PROPOSED EXTENSION AND ALTERATIONS
AT
MAJOR HOUSE, 12 CHURCH STREET
DESIGN STATEMENT

BY
SUNDERLAND PEACOCK ARCHITECTS

Job No. 5927

Rev 1.00_ MARCH 2020

5927 - P01

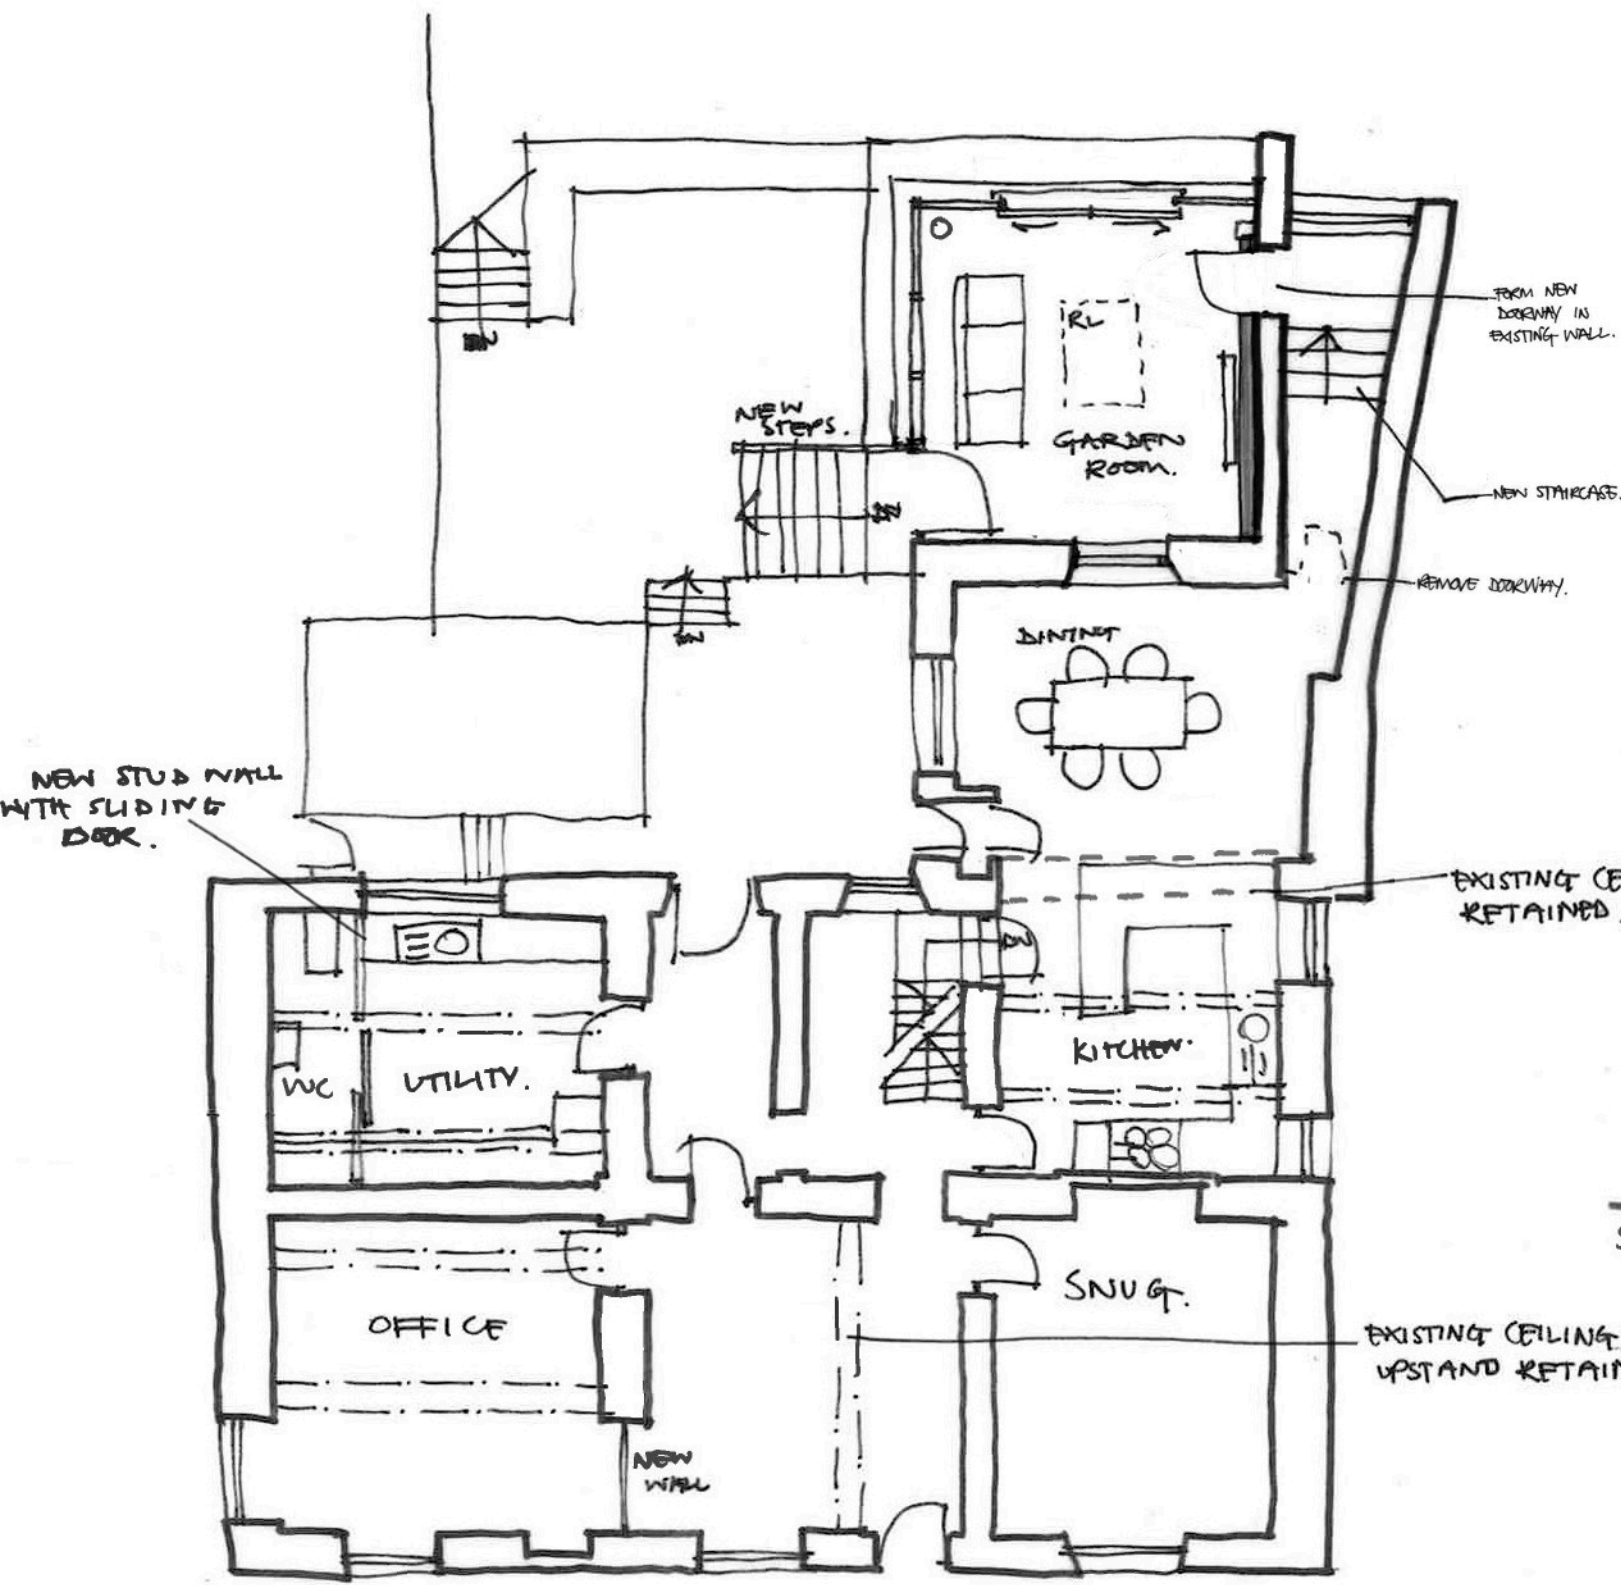
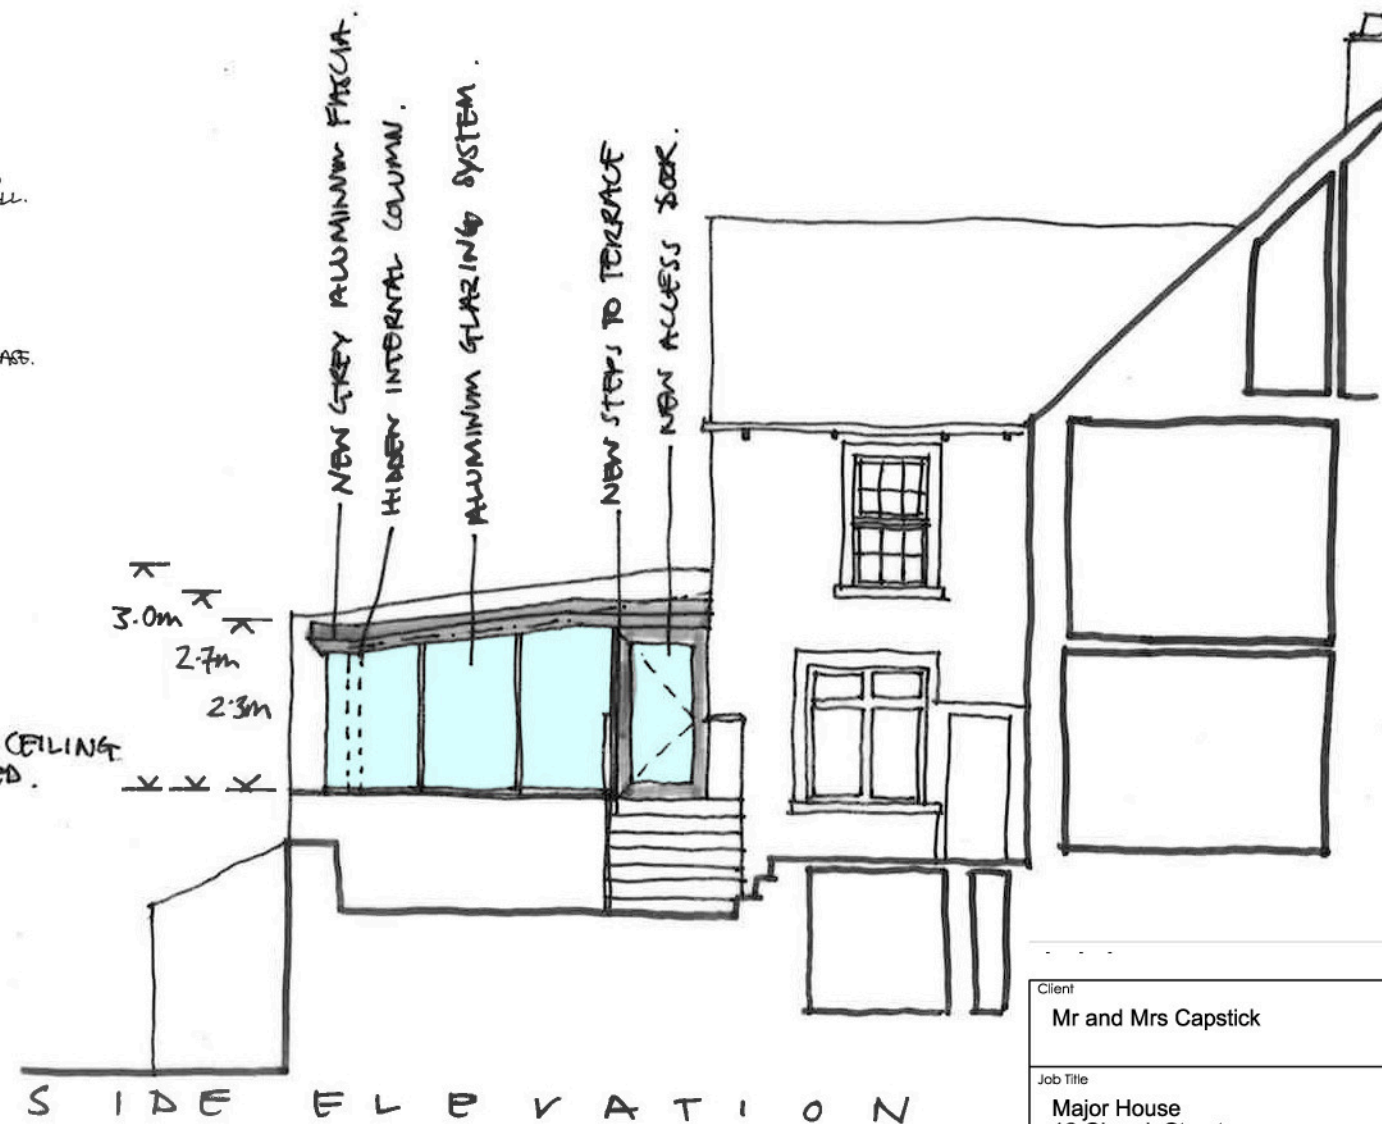
4. It is also proposed to remove a window frame to the rear elevation and replace this with doors to facilitate internal access to the new garden room, this will result in a loss of fabric and would also constitute harm. It is understood that if a new extension is to be accepted then the new structure needs to be linked to the main living accommodation for practical purposes as it is evident that the existing greenhouse is not accessible from the house. This alteration will also have a harmful impact on the historic interest of the building.

SPA response - This design proposal is illustrated in the adjacent images. As a direct response to this item the internal layout has been amended to retain the internal window and create a new access in the narrow space to the side thus eliminating this issue.

5927 - P02

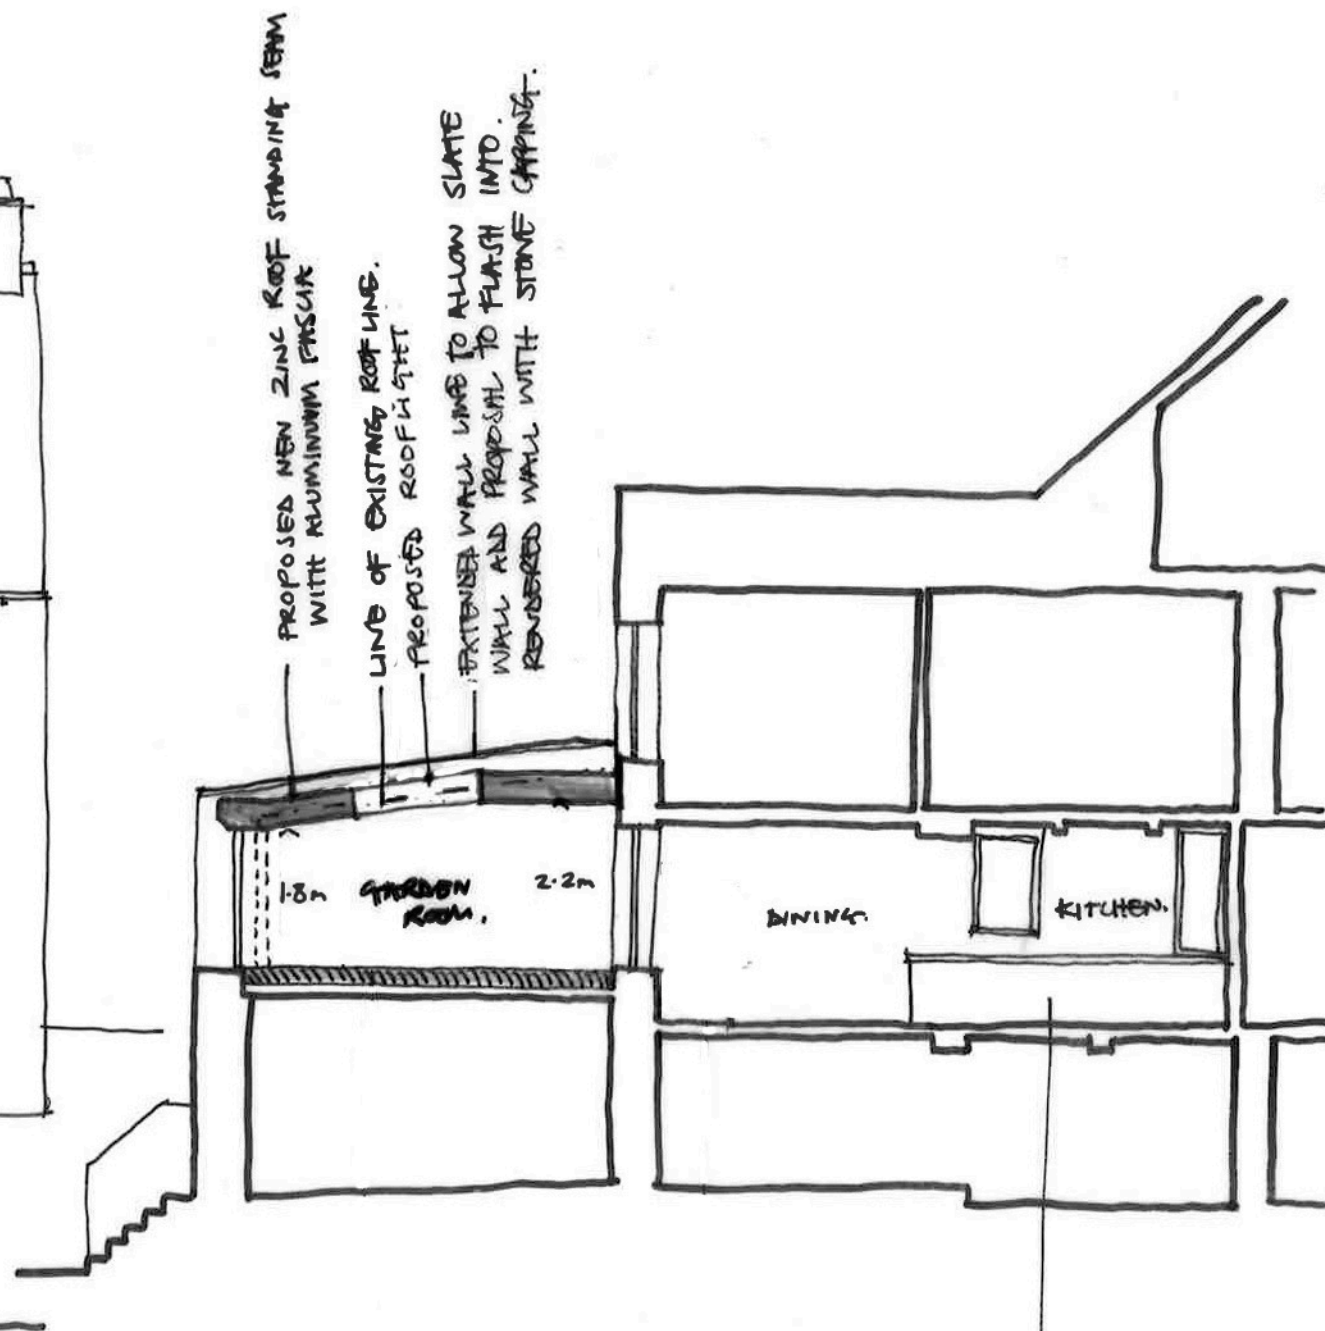
3. *The proposed extension is prominent and elevated above York Street, it would contrast with the original building but would also clearly be read as a later addition. The greenhouse in situ is a lightweight structure and there is a concern that a more solid and permanent structure which will be used more intensively, for example being lit up at night, will have a significant impact and become over dominant. It is considered that the proposed extension would constitute harm.*

SPA response - The design of the extension is intentionally sensitive in design as well as lightweight to limit the impact on the existing listed building. Lighting will be discreet including blinds to create privacy internally and externally.
The extension design will enhance the elevation from York Street through a modern design examples of which are visible along the street scape in other areas.
